OXFORDSHIRE COUNTY COUNCIL'S RESPONSE TO CONSULTATION ON THE FOLLOWING DEVELOPMENT PROPOSAL

Application no: 22/02866/OUT

Proposal: OUTLINE planning application for up to 120 dwellings, vehicular and pedestrian access off Ploughley Road, new pedestrian access to West Hawthorn Road, surface water drainage, foul water drainage, landscaping, public open space, biodiversity and associated infrastructure. Access off Ploughley Road is not reserved for future consideration

Location: Land East Of, Ploughley Road, Ambrosden

JUNCTION VISIBILITY  
SCALE 1:250

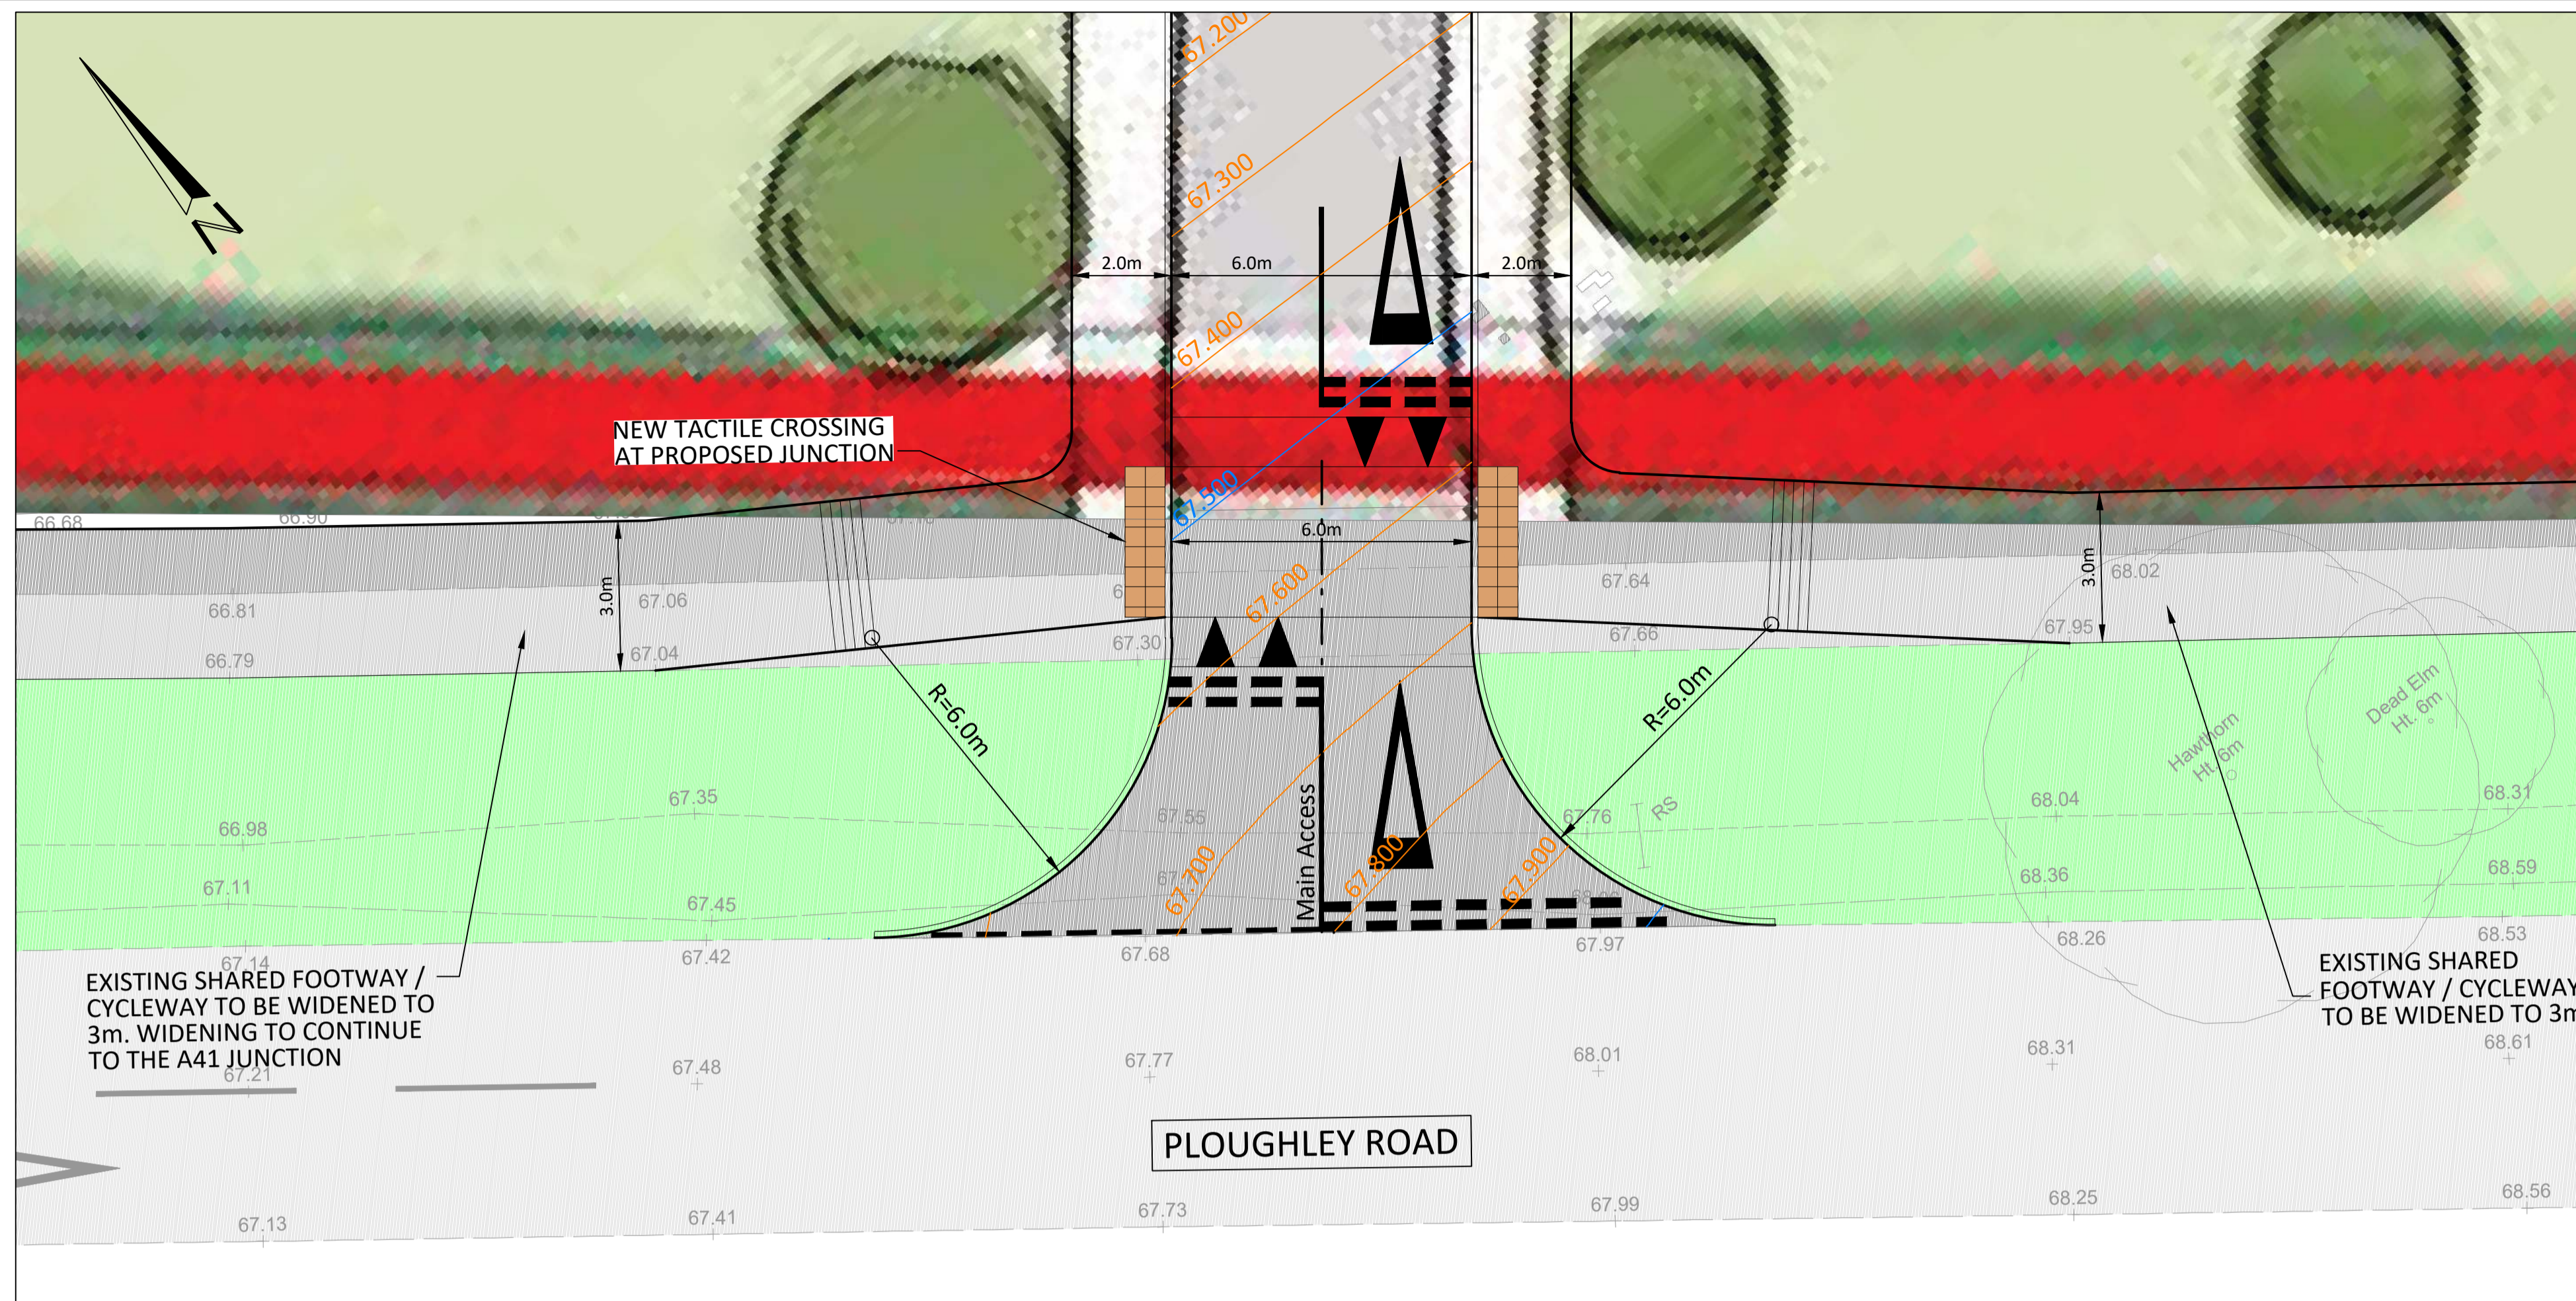
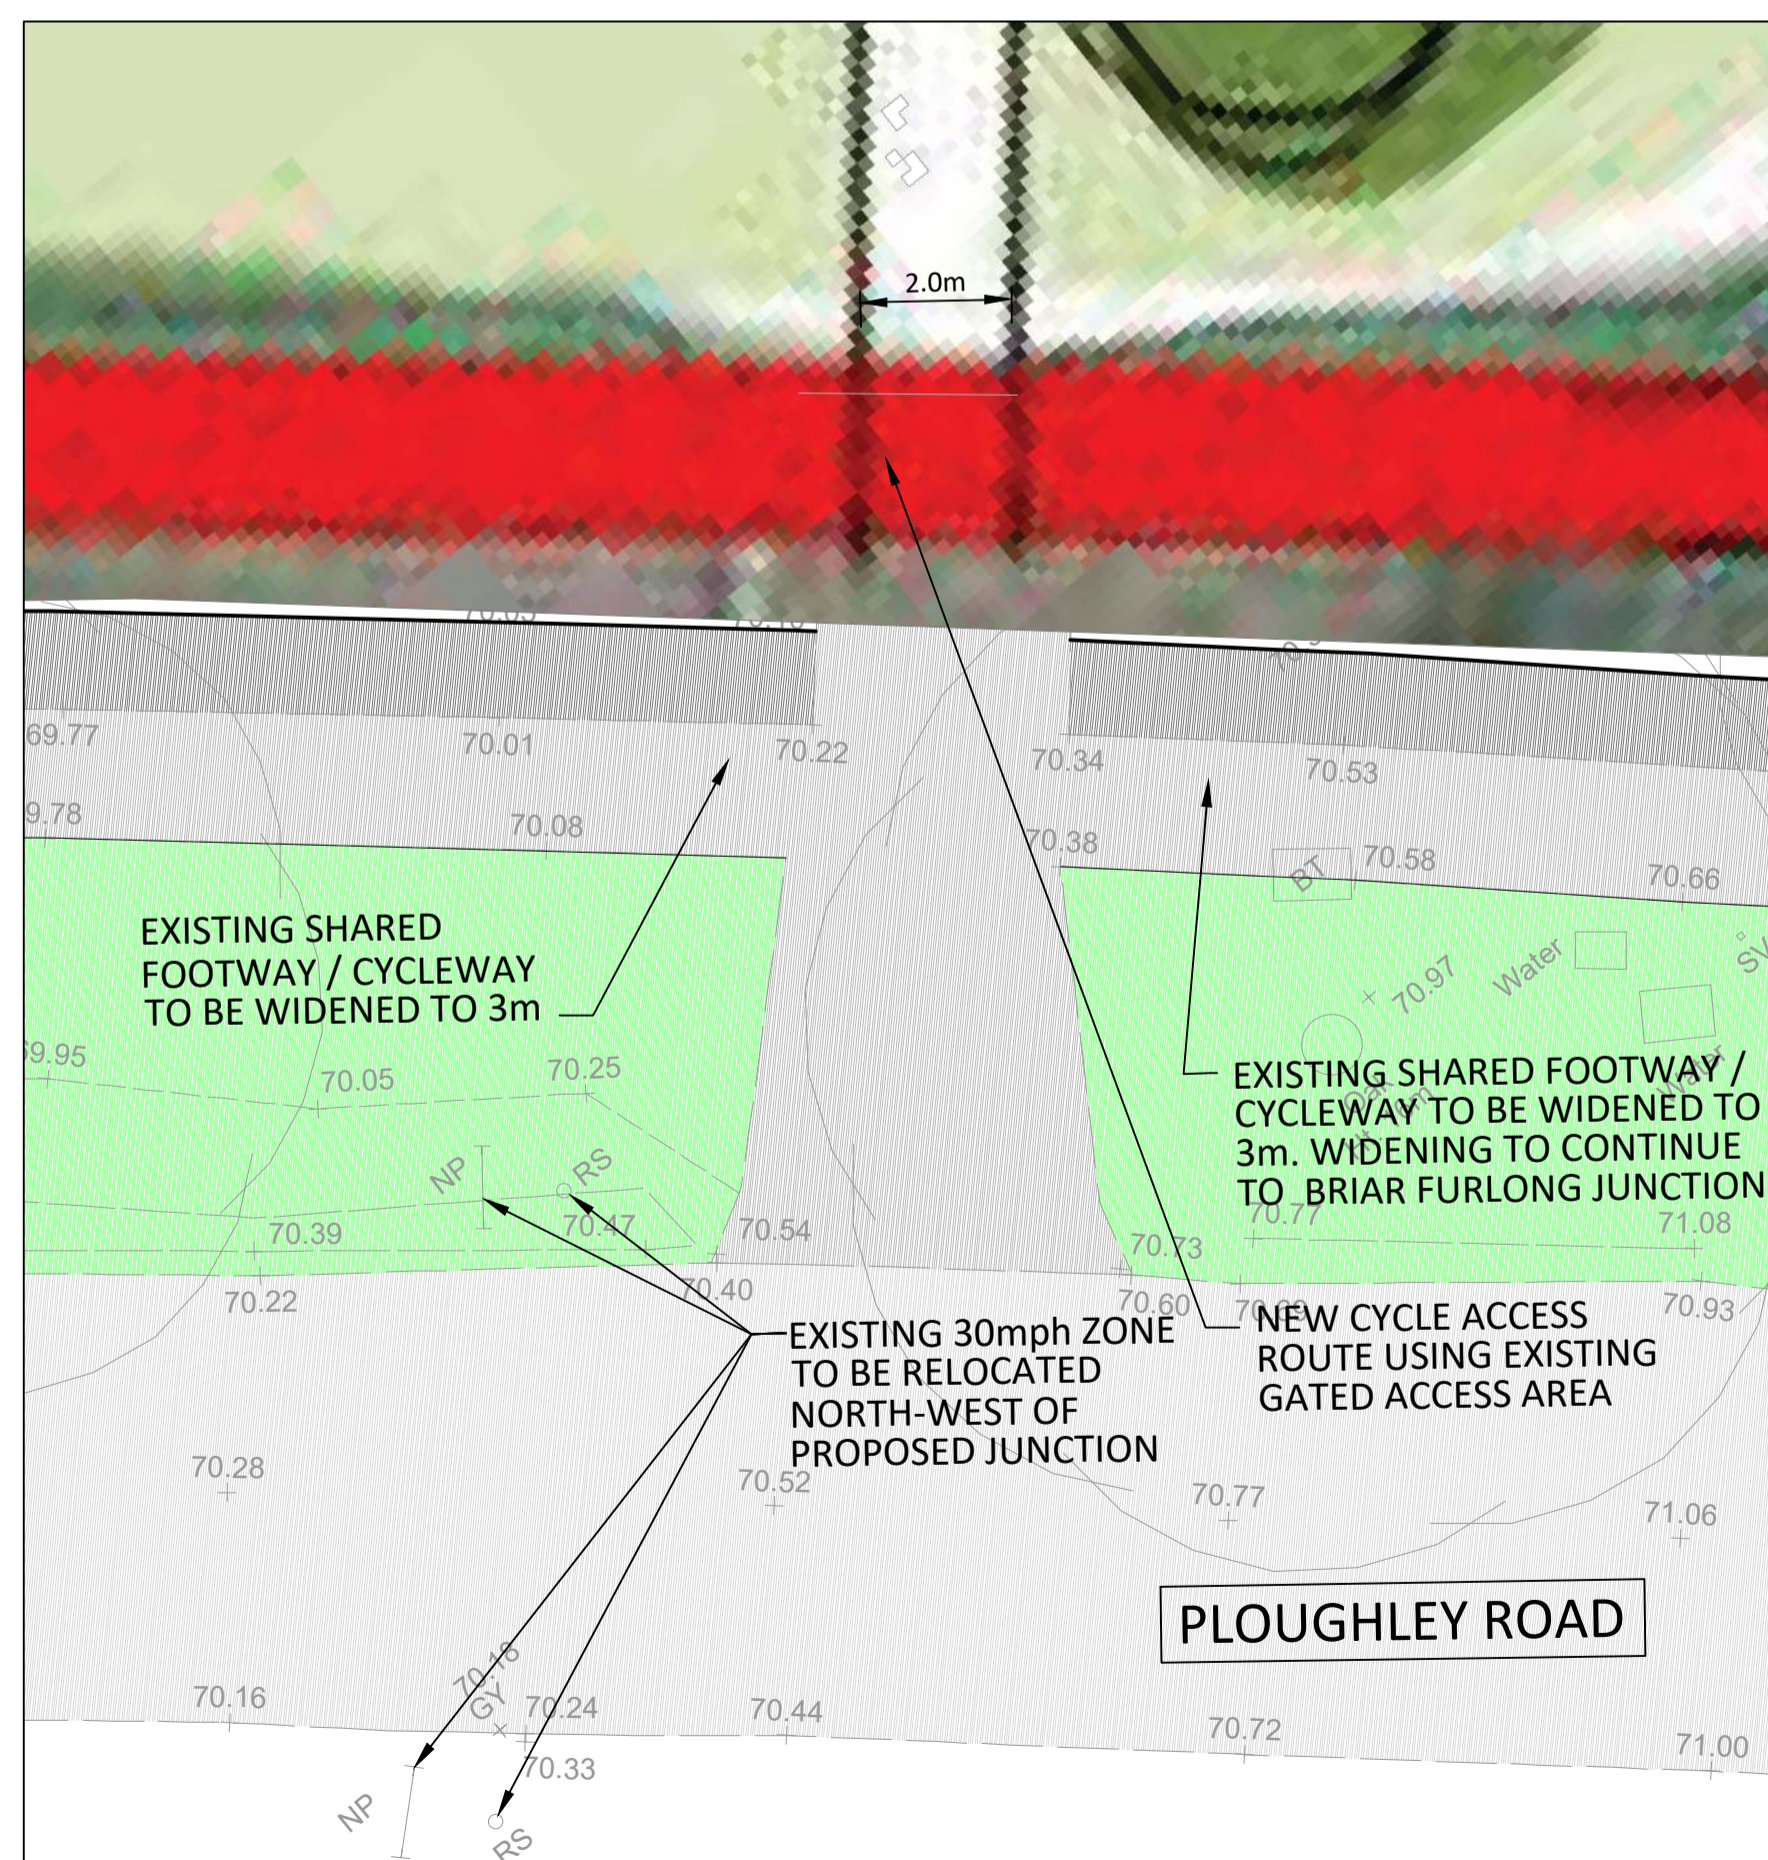
An indicative junction access plan is included in the Design & Access Statement (DAS) and Appendix D of the Transport Assessment (TA). The centreline of the access is approximately 18m from the trunk of a Hawthorn tree in the highway verge.

The TA says that visibility splays of 70m will be provided and I agree that this distance can be achieved in both directions, assuming that the tree growth is managed and the verge vegetation is kept to an appropriate height. The access will be a significant distance from the built-up area of Ambrosden and relatively close to the (relocated) speed limit boundary between 30mph and the 60mph National Speed Limit (NSL). Therefore, it is not definitive which standards should be used for establishing visibility criteria – both Manual for Streets (MfS) and the Design Manual for Roads and Bridges (DMRB) need to be considered.

According to the calculation in MfS, a 70m Stopping Sight Distance (SSD) is equivalent to 43mph. However, MfS is only applicable up to speeds of 37mph.

According to DMRB, a 70m SSD is equivalent to 32mph.

The built-up area effectively ends at the entrance to the Bicester Garrison centre, 160m from the site access, and there is no streetlighting north of there, so it is highly likely that the majority of outbound vehicles will significantly accelerate, despite remaining in the proposed 30mph area that will only be indicated by speed limit repeater signs. Indeed, any overtaking manoeuvres on exit from the village may result in the faster vehicle proceeding northwards in the southbound lane, significantly reducing the visibility from the site access.

Southbound vehicles from the A41 will leave the NSL at a point which is proposed to be about 100m from the site access. It is considered that most vehicles will not decelerate fast enough to be moving at a speed appropriate to the visibility splay length when they first come into view.

Given the above, OCC consider that the available visibility from the site access is insufficient for the anticipated vehicle speeds along Ploughley Road, despite the proposed change to the speed limit, and this is a reason to **object**.

The bellmouth access must include a cycletrack crossing in accordance with LTN 1/20, as noted in sect. 5.3 of the TA.

OCC believe that the introduction of traffic-calming measures could potentially ensure that vehicle speeds are reduced to acceptable levels. There is a valid precedent on Ploughley Road at the south side of the village where two build-out features have been approved and constructed.

A similar proposal adjacent to the site may be appropriate. If the application is to be approved, OCC require suitable traffic-calming measures to be provided as part of the S278 works. Any features must be designed to accommodate oversize military vehicles and large agricultural plant, and any vertical deflections along a bus route are subject to agreement with the bus operators.
